Our Ref: WA/85/19/HH

**Town & Country Planning Act 1990 (as amended)
Town & Country Planning (Development Management Procedure) (England) Order 2015
Application for Planning Permission for Works or Extension to a Dwelling**

Development Proposed loft conversion, new dormer and alterations to front entrance porch

Location 20 Henty Close Walberton

Proposed Elevations

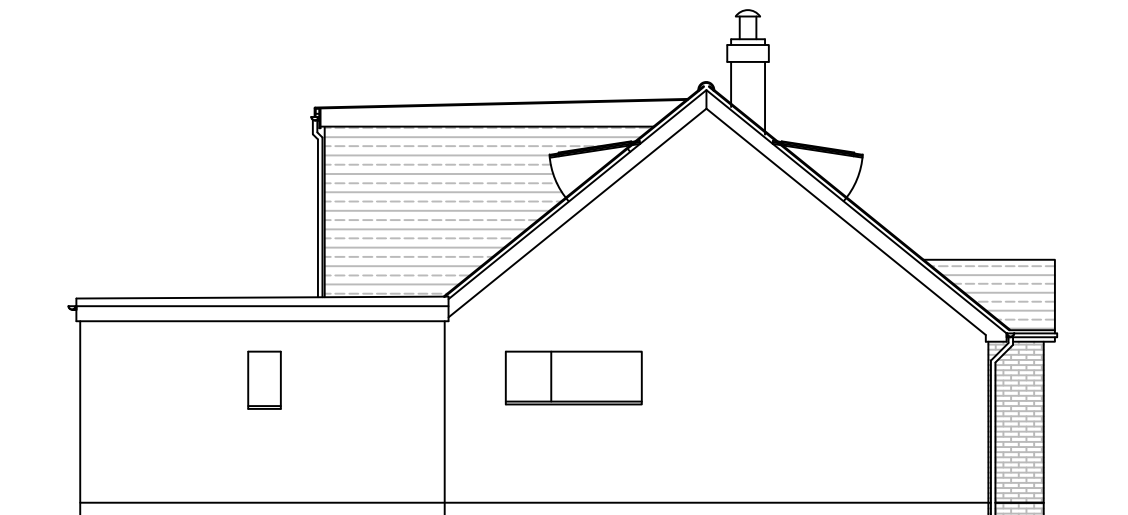
The Proposed porch floor plan is inconsistent with the proposed elevation (missing window)
Lidsey Foul Water - Environmental Assessment
